Ribble Valley Borough Council
Housing & Development Control

Application no: **3/2022/0279**

Address: **Talbot Hotel 5 Talbot Street Chipping PR3 2QE**

The Local Highway Authority have viewed the plans and highway related documents and have the following comments to make:

Drawing Title
Proposed Site Plan

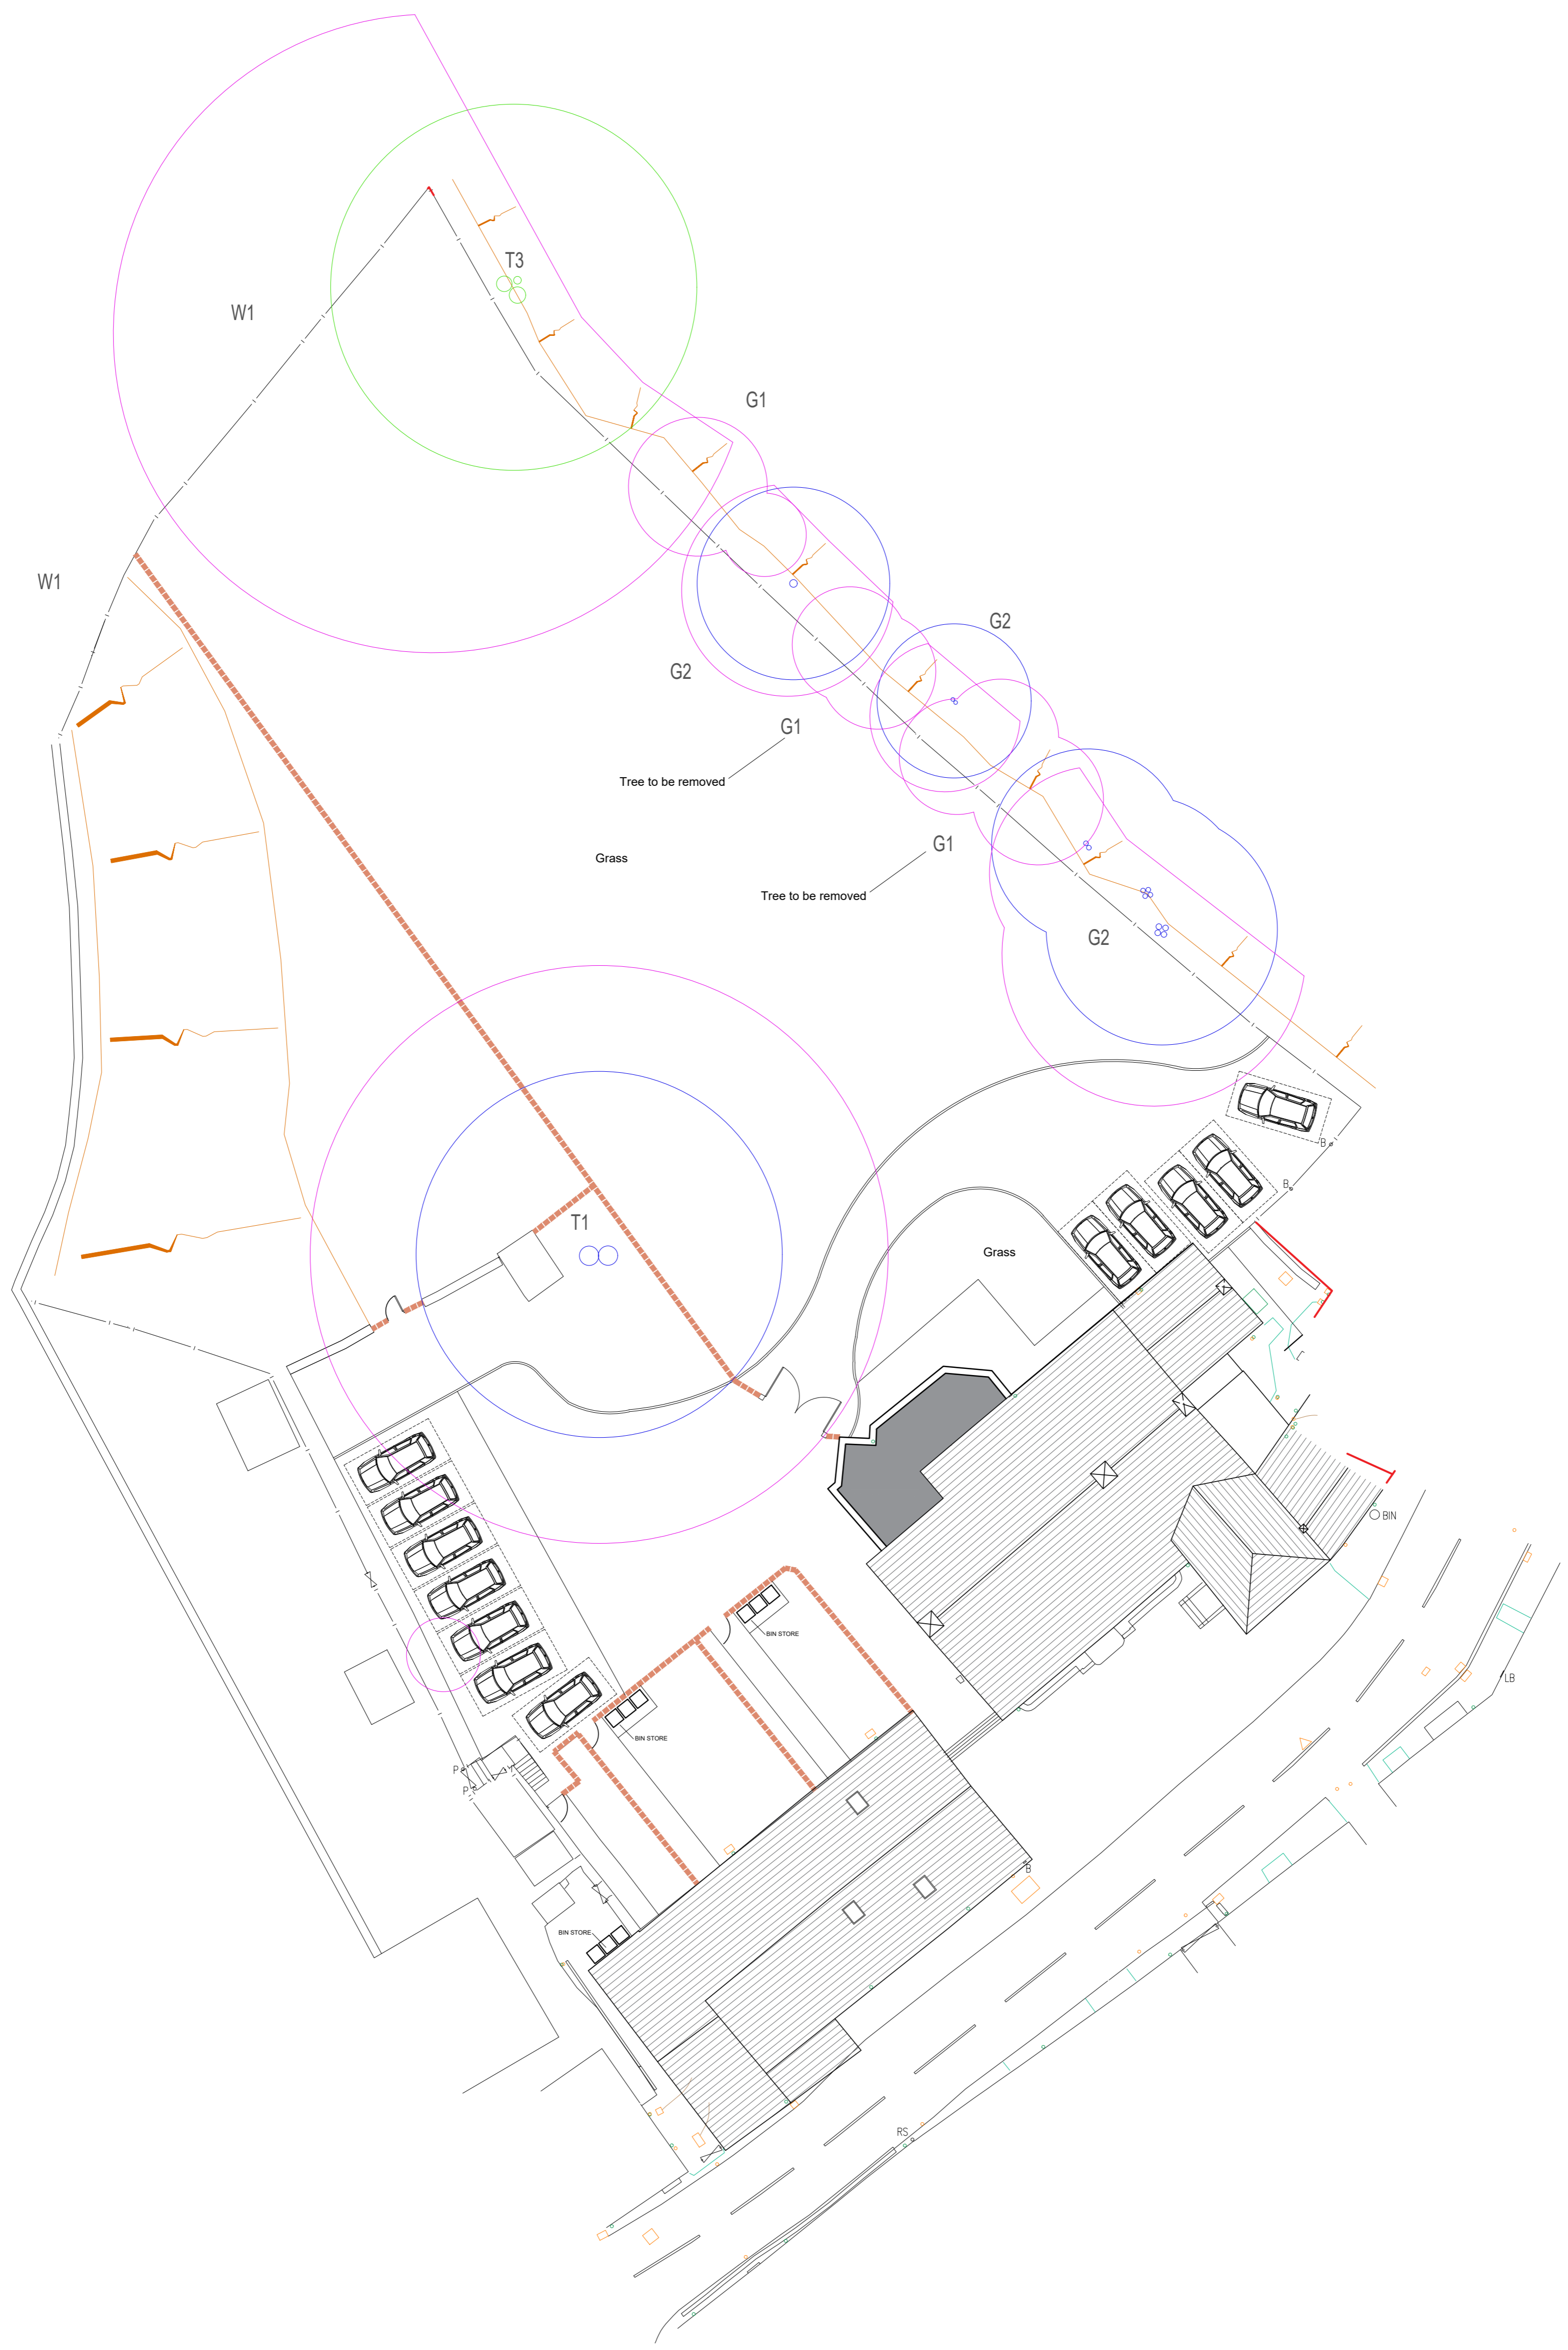
The LHA have reviewed SPA drawing number 6521- P04 Rev B titled "Proposed Site Plan" and are aware that the access will be a minimum of 4.25m wide for a distance of approximately 8m from the adopted highway.

While this does not strictly comply with the LHAs guidance for an access serving 2 or more dwellings, which requires the access width of the access track to be 4.25m for the duration of its length, the LHA will accept the shortfall. This is because of the site being existing and the use of the access not being to intensify like the previous use as well as the previous approval, under application reference 3/2012/0962 which was the refurbishment of the existing hotel and bar area among other amendments.

The LHA have reviewed SPA drawing number 6521- P04 Rev B titled "Proposed Site Plan" and are aware that the proposed parking arrangements complies with the LHAs parking guidance found in the Joint Lancashire Structure Plan for the scale of development. Therefore, the LHA have no further comments to make regarding the site.

2. No part of the development hereby permitted shall be occupied until such time as the access arrangements shown on SPA drawing number 6521- P04 Rev B have been implemented in full.

3. The development hereby permitted shall not be occupied until such time as the access drive (and any turning space) has been surfaced with tarmacadam, or similar hard bound material (not loose aggregate) for a distance of at least 8 metres behind the highway boundary and, once provided, shall be so maintained in perpetuity.

4. The development hereby permitted shall not be occupied until such time as the parking and turning facilities have been implemented in accordance with SPA drawing number 6521- P04 Rev B. Thereafter the onsite parking provision shall be so maintained in perpetuity.
